Re: Proposed development N70 Waterville to Ballybrack Road Improvement Scheme
Townlands of Waterville, Ballybrack and Eightercua, Co. Kerry

Re: Application of Kerry Council for Consent for Proposed Development (N70 Waterville to Ballybrack Road Improvement Scheme) – Our Clients Eddie Cagney and Ann Roche-Cagney, 6 Benjamin Close, Ballybrack, Waterville, Co. Kerry

PROPOSED N70 WATERVILLE TO BALLYBRACK ROAD IMPROVEMENT SCHEME

Submission made on Behalf of Eddie
Cagney & Ann Roche-Cagney,
6 Benjamin Close, Ballybrack

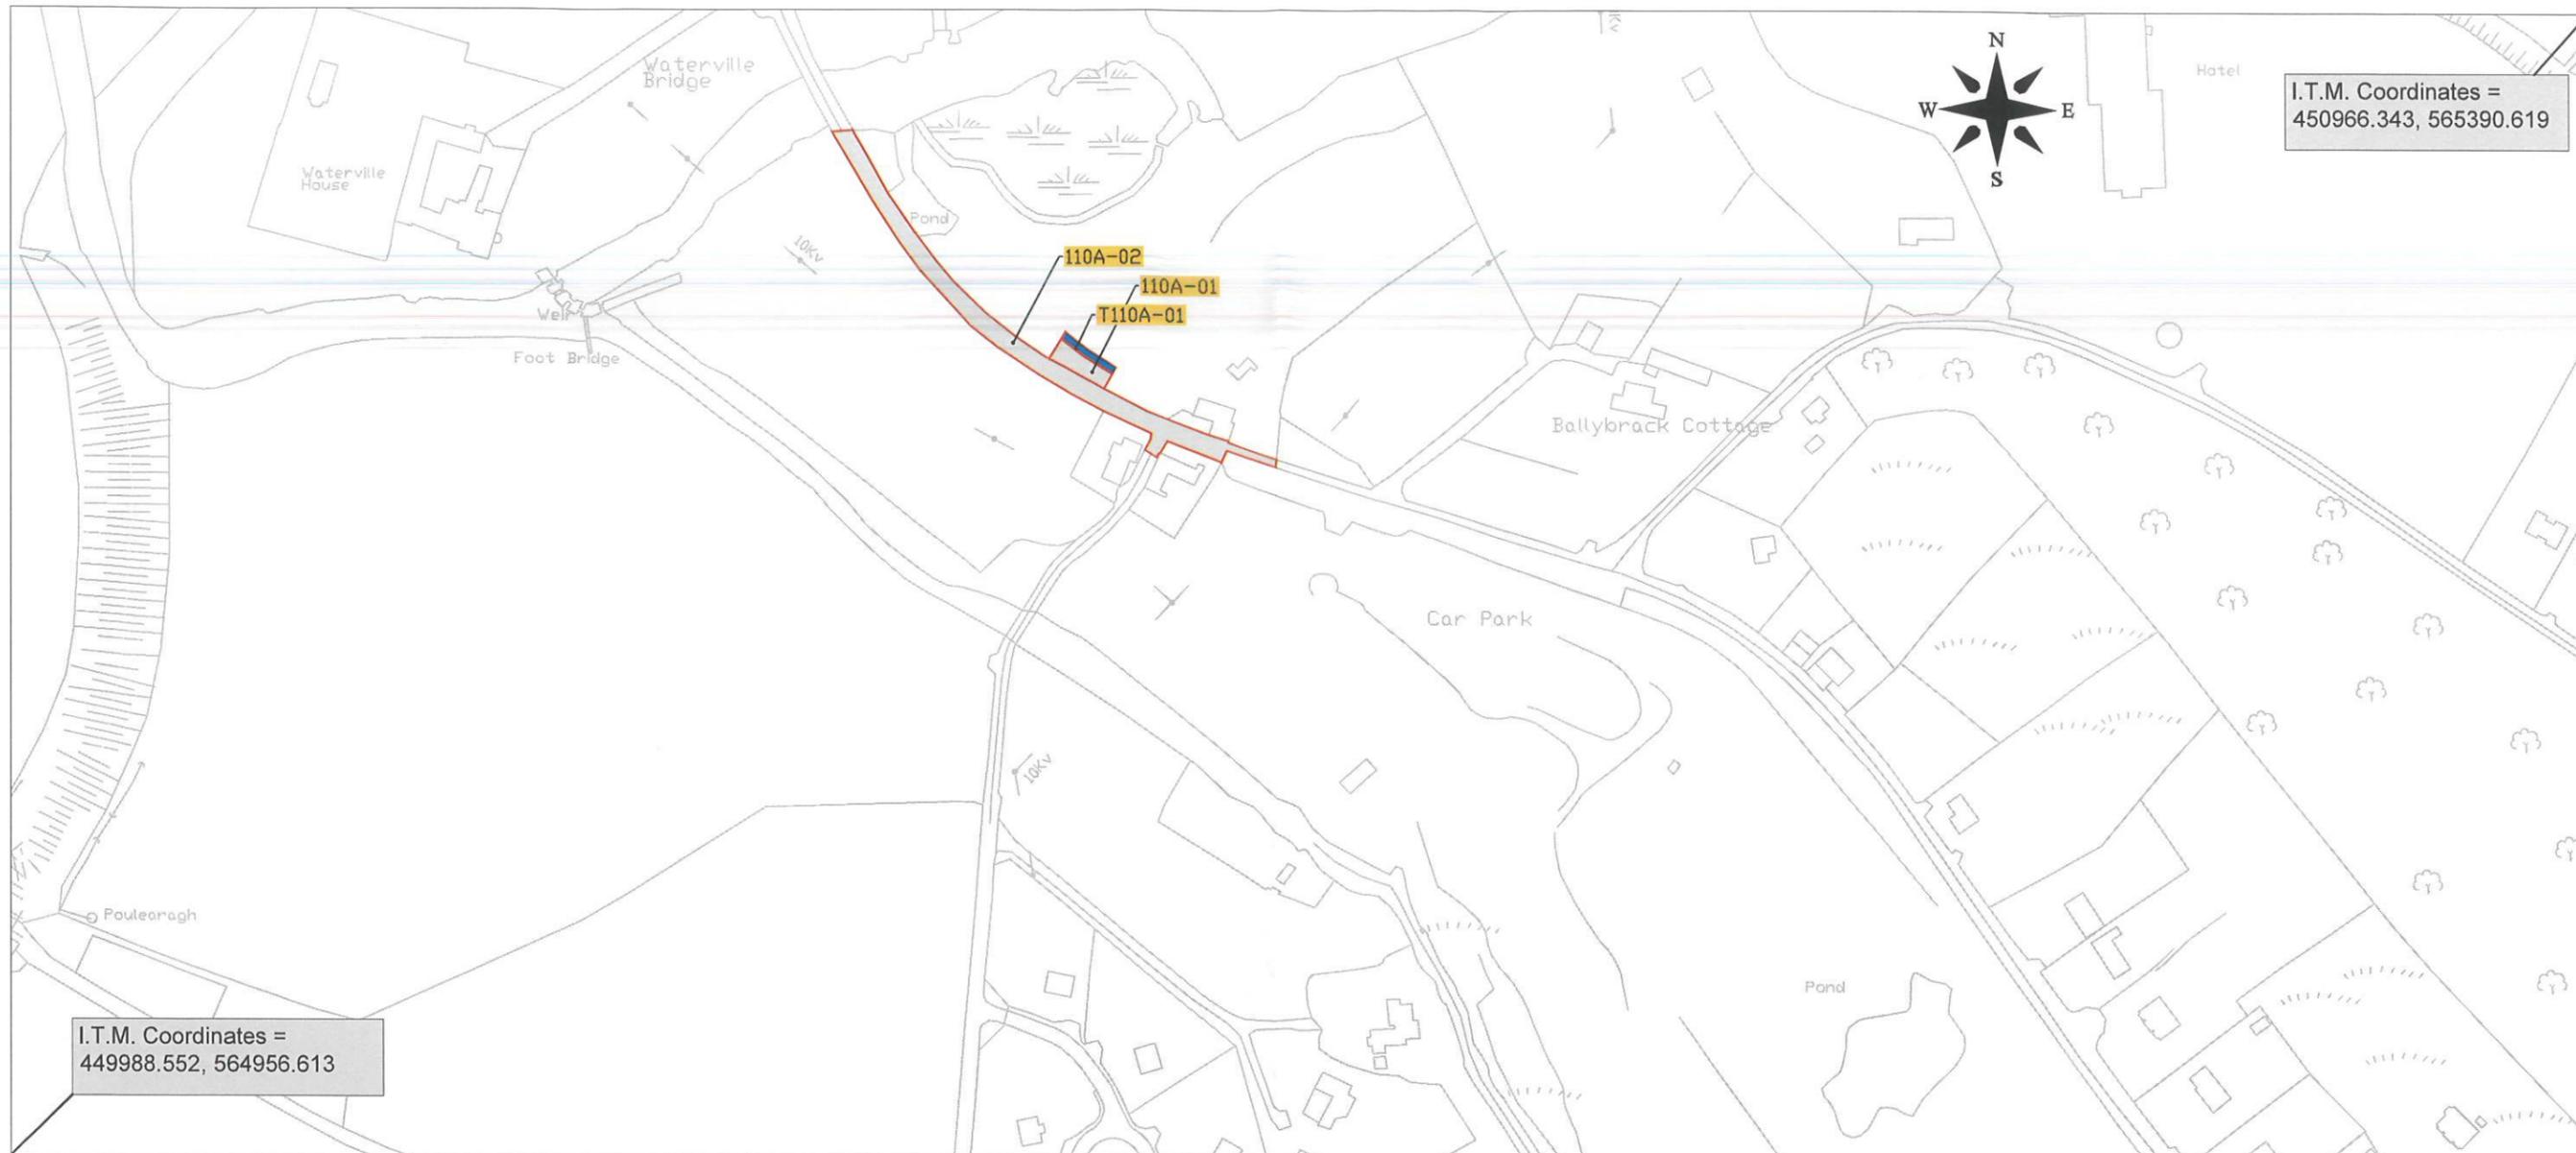
2.2: In addition, there is a distinct lack of clarity and exactness in regard to the precise extent of the “take” suggested –

- the maps are not as definitive as they might seem – the precise computer-drawn lines on the CPO maps are presumably accurate but are, to scale, almost 1 m wide – is the boundary on the inner or outer edges or the centreline of this 1m width? Is the new roadside boundary to be constructed within the “take”? (it would appear that there is insufficient provision for same).

- There is a distinct “twist” shown on the Northern end of the boundary between 130-01 & T130-01 - see enlargement on Right - is it intended that there would be a matching physical Twist?

- It is noted that, measured on the ground, the roadside face to roadside face of our clients’ roadside stone wall/ditch is c. 2.1 m nearer the road than the cut-stone wall fronting his neighbour’s site to the North. However, with a 50m road frontage, a rectangle of 156m² (Area from CPO schedule) would have a depth of c. 3.1m.

- Given the last 2 points, are we correct in assuming that our clients’ lawn would, post works, be shallower than that of the Neighbour to the North?
- As a further complication, the 130-01/130-02 boundary, which on the face of it, should coincide with the existing roadside boundary, has an unexplained kink near the Southern end – see detail on Right. This kink does not exist on the ground, nor is it reflected in either your Engineers’ detailed surveys or the OSI maps. What if anything, is its significance??

- Given all of the above, what would in any case be a not-unreasonable expectation that the proposed land take would be physically pegged now becomes an essential exercise, and we would request that this be done urgently.

Title: **Fencing, Walls and VRS Sheet 01 of 02**

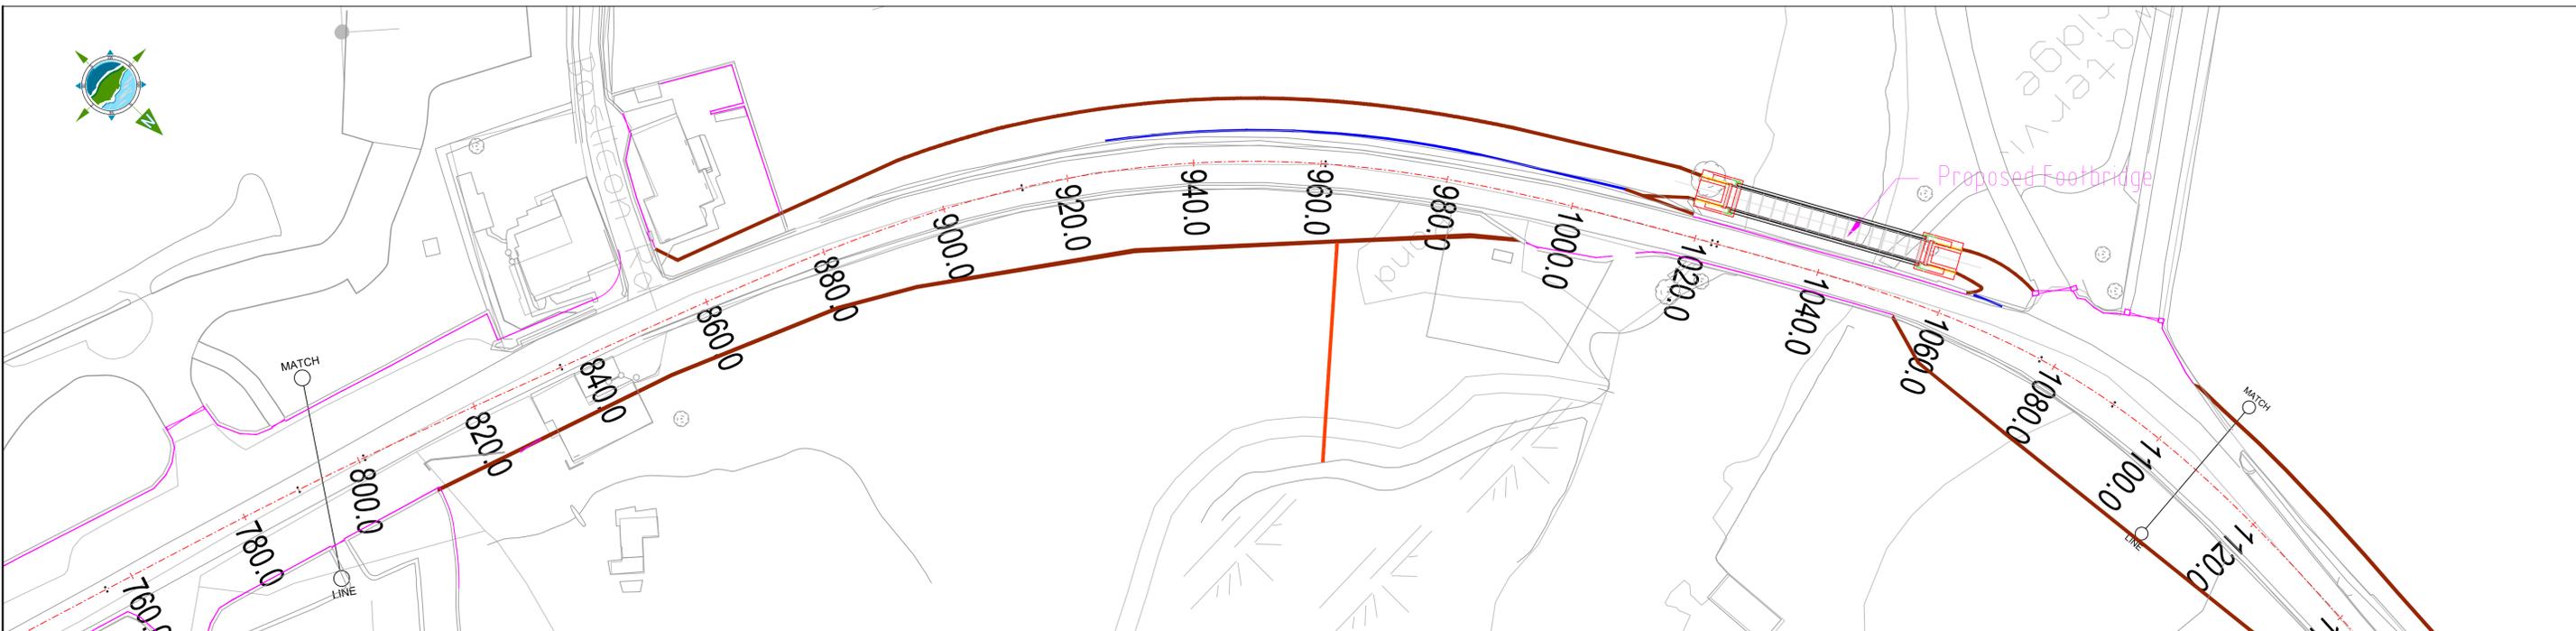
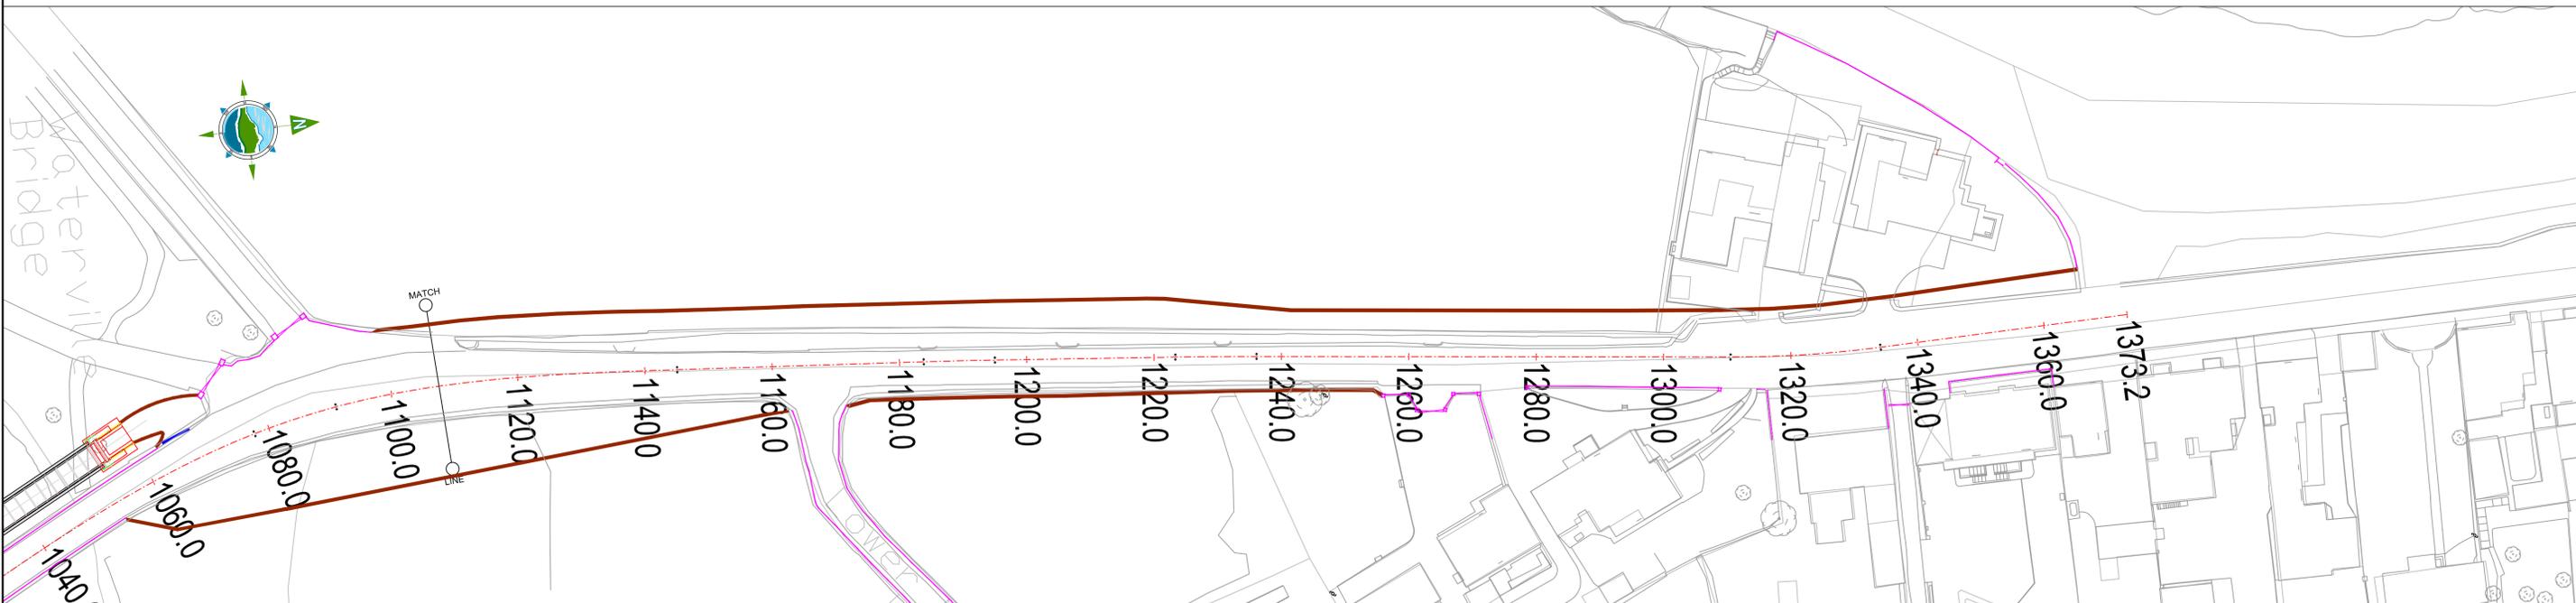
6.1: The existing roadside boundary structure is a stone & slightly sodded construction. Our Clients have, over the years, cleaned it down and made it a feature of their garden – see below. They have also, but less diligently due to the difficulty of working safely on the roadside, kept the external face clean and in good condition.

They would require that any replacement wall be of similar construction – not just the standard stone-faced blockwork. This is in part to maintain the character of their boundary, but is also in recognition of the heritage of the area, and with particular reference to the Megalithic Monument known as the Eightercua Stone Row, which is situated less than 400m. away.

6.2: Also, the existing ditch, while shown on the sections as only 600 mm high, is actually 1000 > 1400 over the road level. Our Clients would require that any replacement be 1400 high. This would more closely reflect the existing position, but the increased pedestrian & cycle traffic that will result from the proposal is also a factor to be taken into account.

6.3: As illustrated in the Section at 5.1 above, the thickness of such a wall will also be a factor in determining the exact land take required, and the Council may need to put some further thought into this.

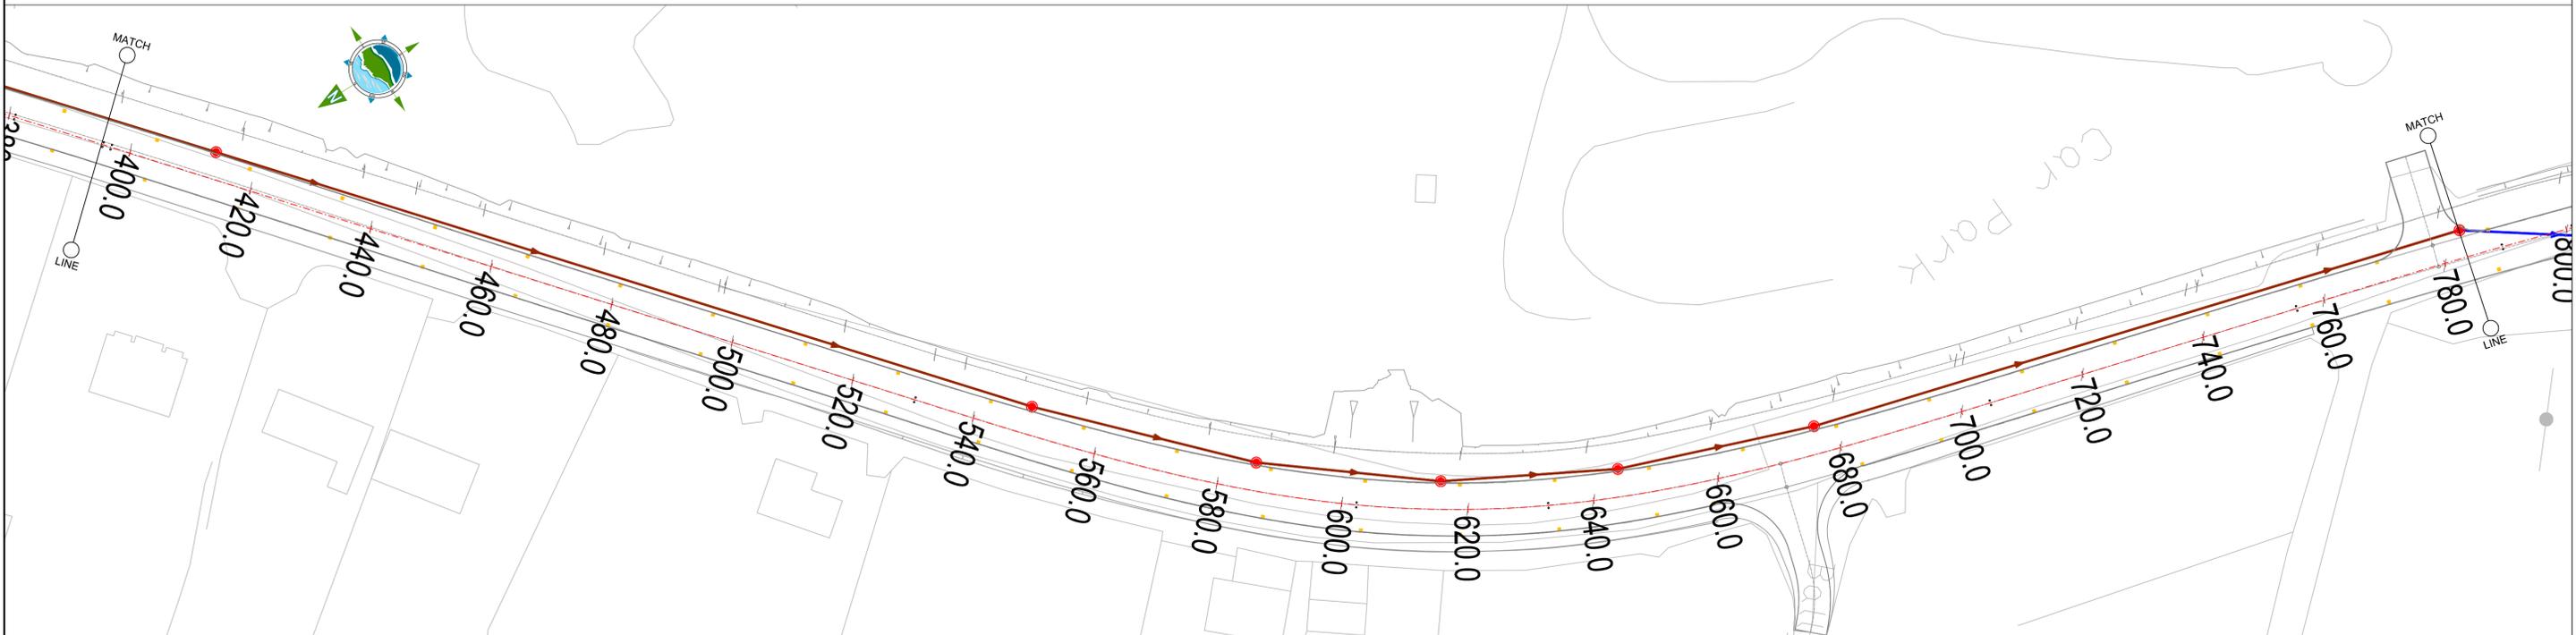
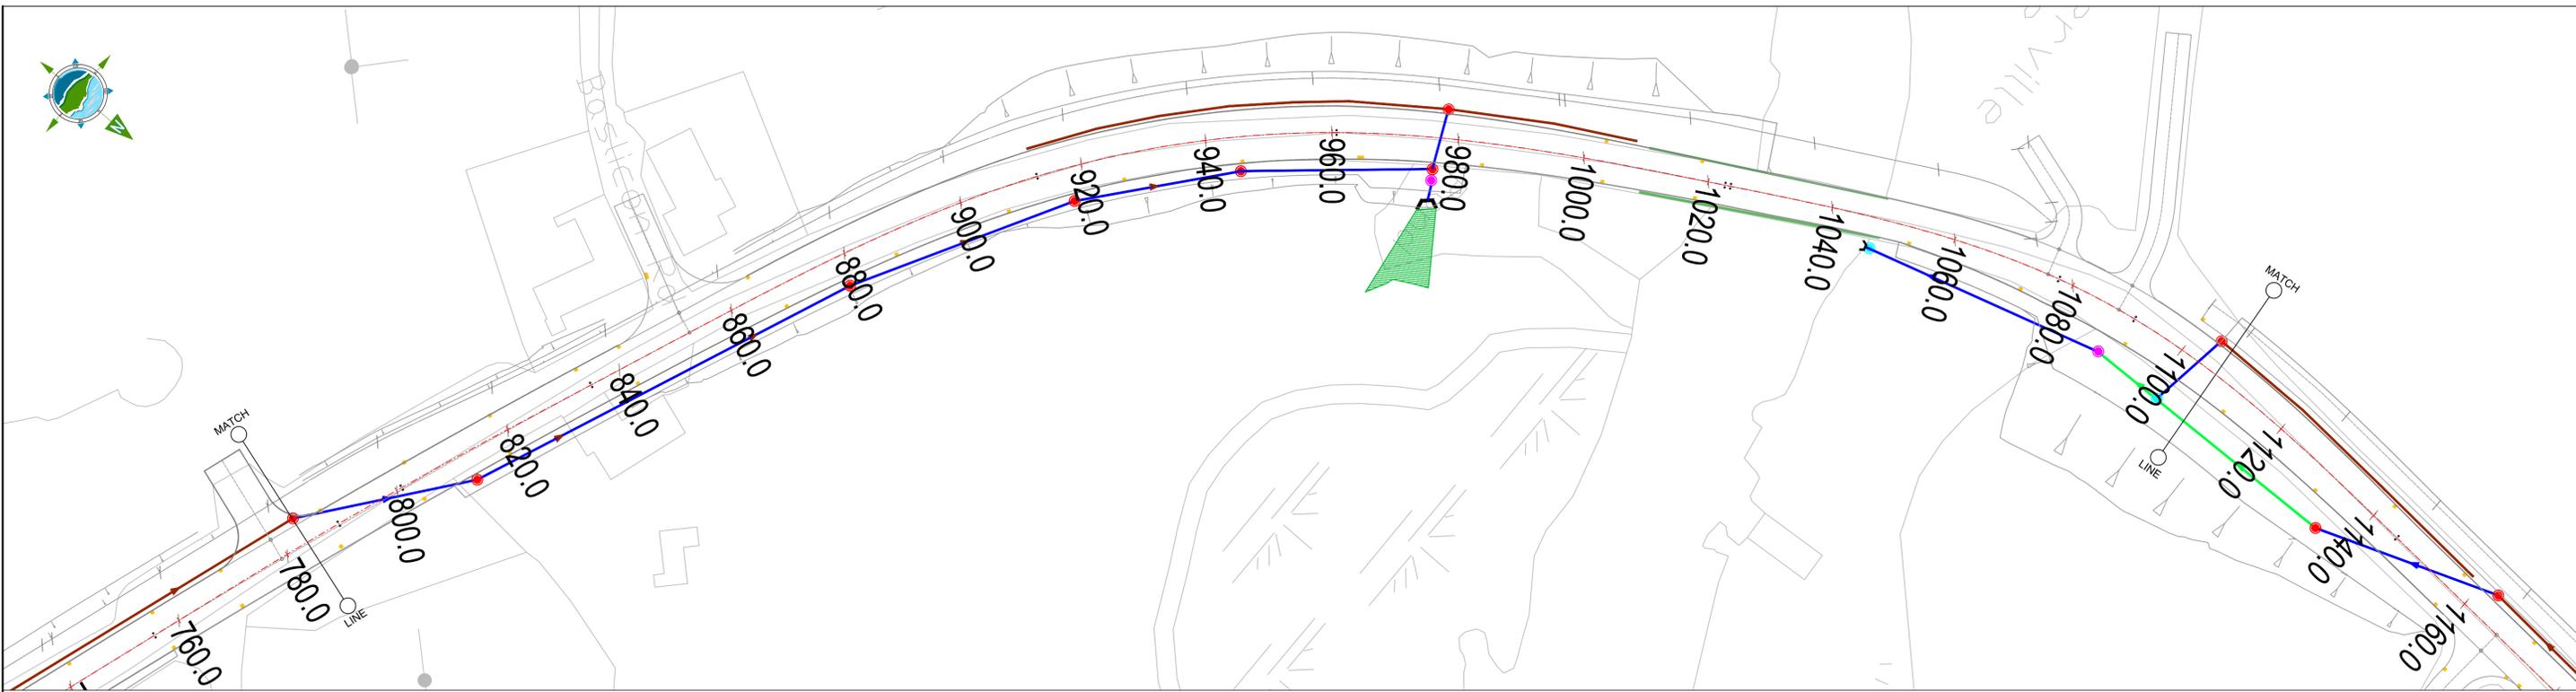
5.1: Now, to make matters worse, the same Council are proposing a road scheme that will, at once, at least potentially slightly increase the total inflow from the road into their site, but also will infill the bulk of the lowest part of their lawn, thus infilling the swale or sump described above. The Diagram below is approximately 1:50 Scale, but in any case illustrates the main issue (i.e. what is to become of the swale?) quite well. The existing road, ditch & lawn levels are shown in Black, with the new proposals in Red

Critically, note the identification in Blue of a “Swale” to be lost. This is as described in 4.4 above, and intentionally or otherwise, forms the essential element of the existing, albeit poor, Surface Water “disposal” regime. If this is lost, and if complete waterlogging of much of our clients’ Lawn, not to mention interference with the drainage from the entire of the site, **an alternative must be found**

5.3: All-in-all, it would seem that the only satisfactory solution here would be to ensure that the main C drain proposed under the new road would be 1m+ clear of the surface (good or normal practise anyway?), and provide connections from this into all of the sites adjoining the N70, but most particularly into our clients’ site, as it is here that much of the overall Benjamin Close surface water gathers.
